## Planning Application - Anglian Water Response

<b>Anglian Water site reference:</b>	PLN-0237550
<b>Response date:</b>	29 January 2026
<b>Local Planning Authority:</b>	South Holland
<b>Planning application reference:</b>	H16-1191-25
<b>Site address:</b>	39-41 Albert Street Spalding PE11 2LD
<b>Proposal description:</b>	Demolition of redundant commercial buildings and the erection of 5 dwellings

PROPOSED BLOCK PLAN

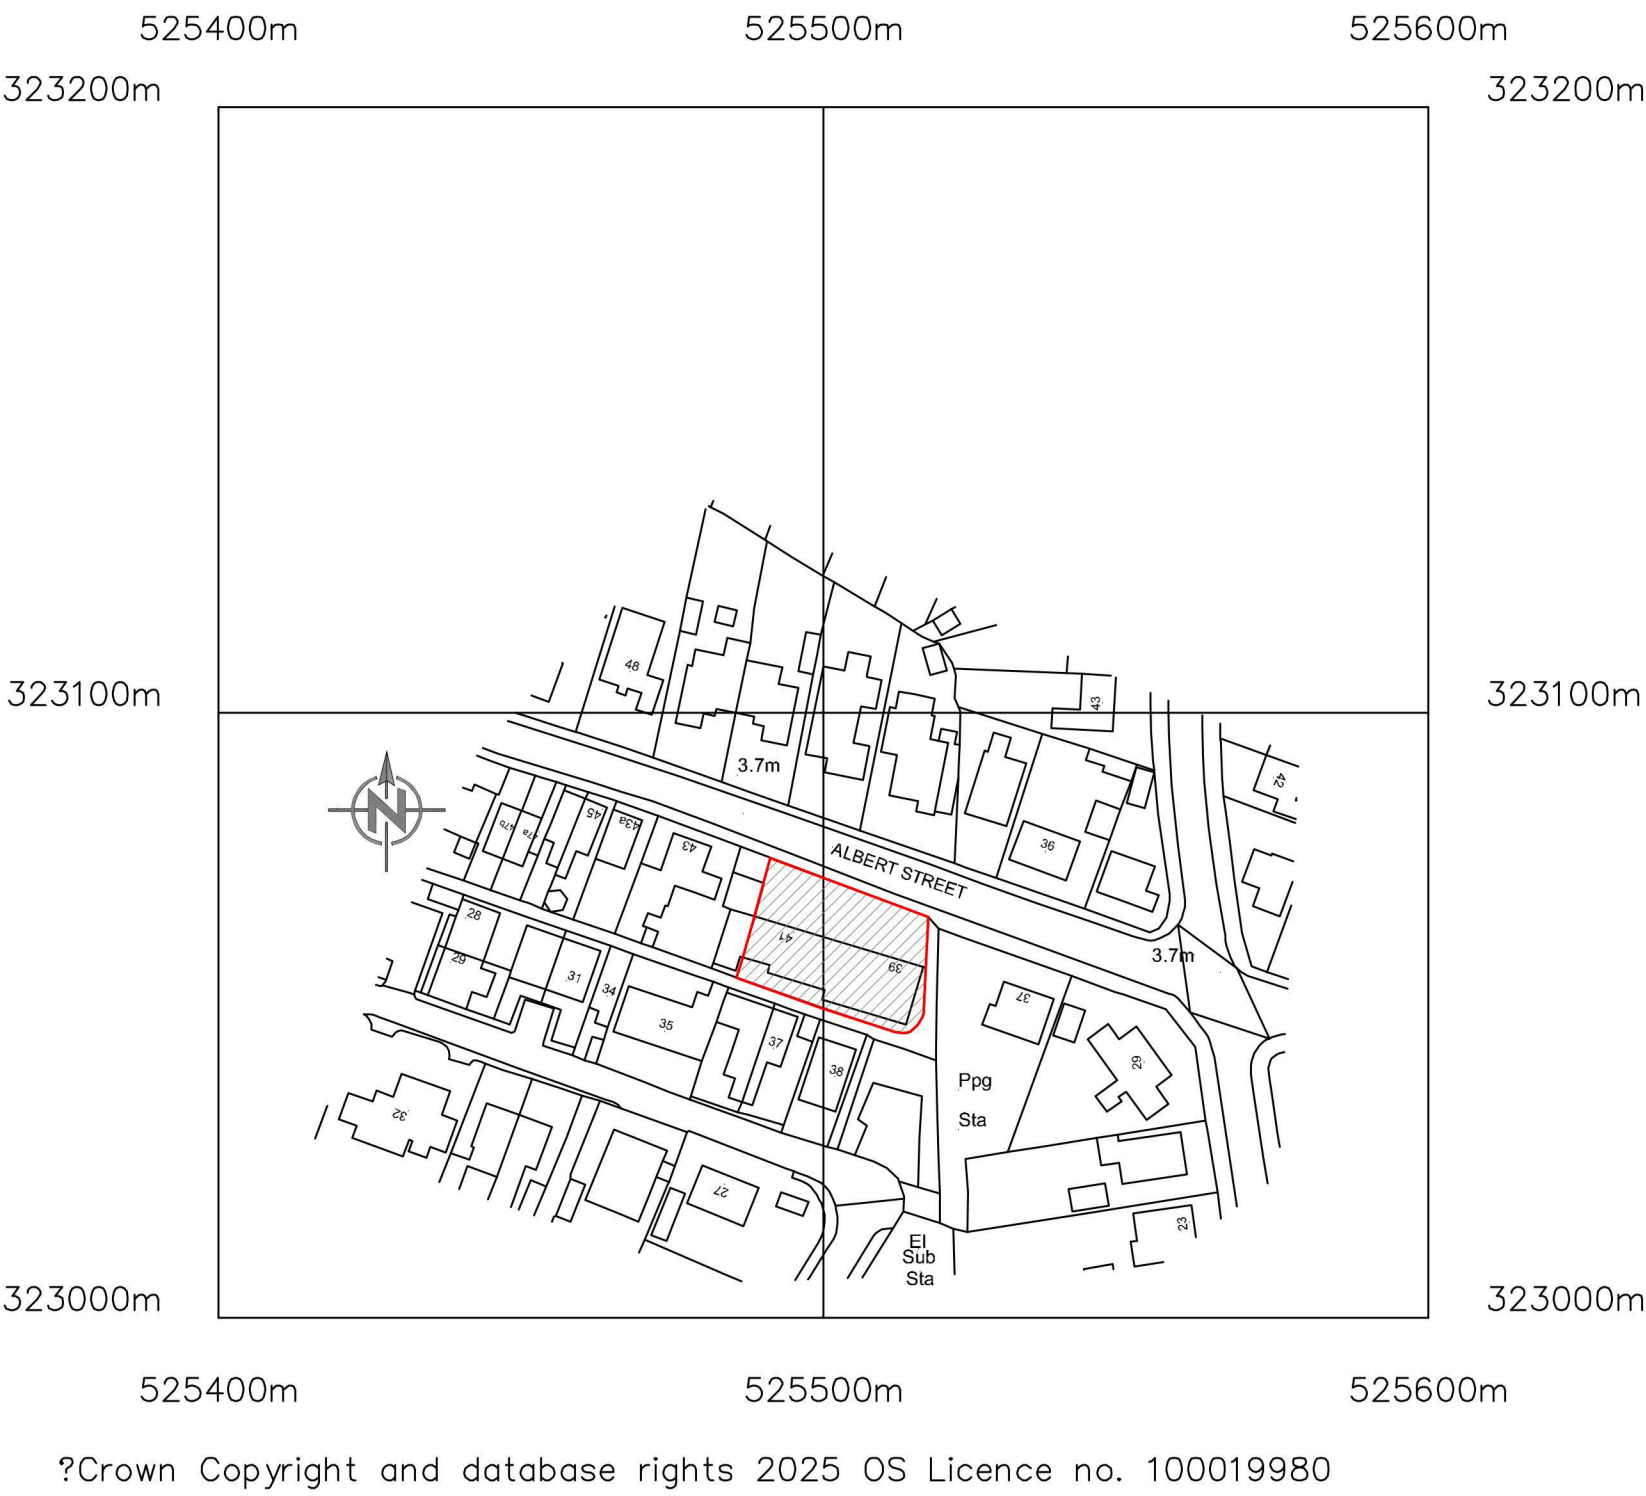
We need to inform you that there is a 225mm foul sewer, 250mm foul rising main and 3inch water main which are close to or crossing the site and are affected by the proposed development. We have reviewed the submitted development layout plan and we can see that Plot 5 is affected by the above Anglian Water owned assets.

Anglian Water acknowledge the existing building already close to or over our asset. Nevertheless, for new development Anglian Water does not permit these assets to be located within the curtilage of the proposed building. These assets should be located in areas of public open space and/or adoptable highways to ensure on-going maintenance and access is possible. The site layout plan, as submitted, indicates that the above assets may be located within the curtilage of a building. We strongly recommend that the applicant reviews the site layout plan and takes the above in consideration to reflect the easement required for the sewer which is 3 metres both side of the sewers, and 4.5 metres overall for the water main.

To overcome our objection the site layout needs to take into account the location of the asset, and it should be referred to in any master planning exercises or site layout plans submitted as part of any subsequent planning application. We require all Anglian Water assets to be plotted on layout plans, with accompanying easements shown, for absolute clarity.
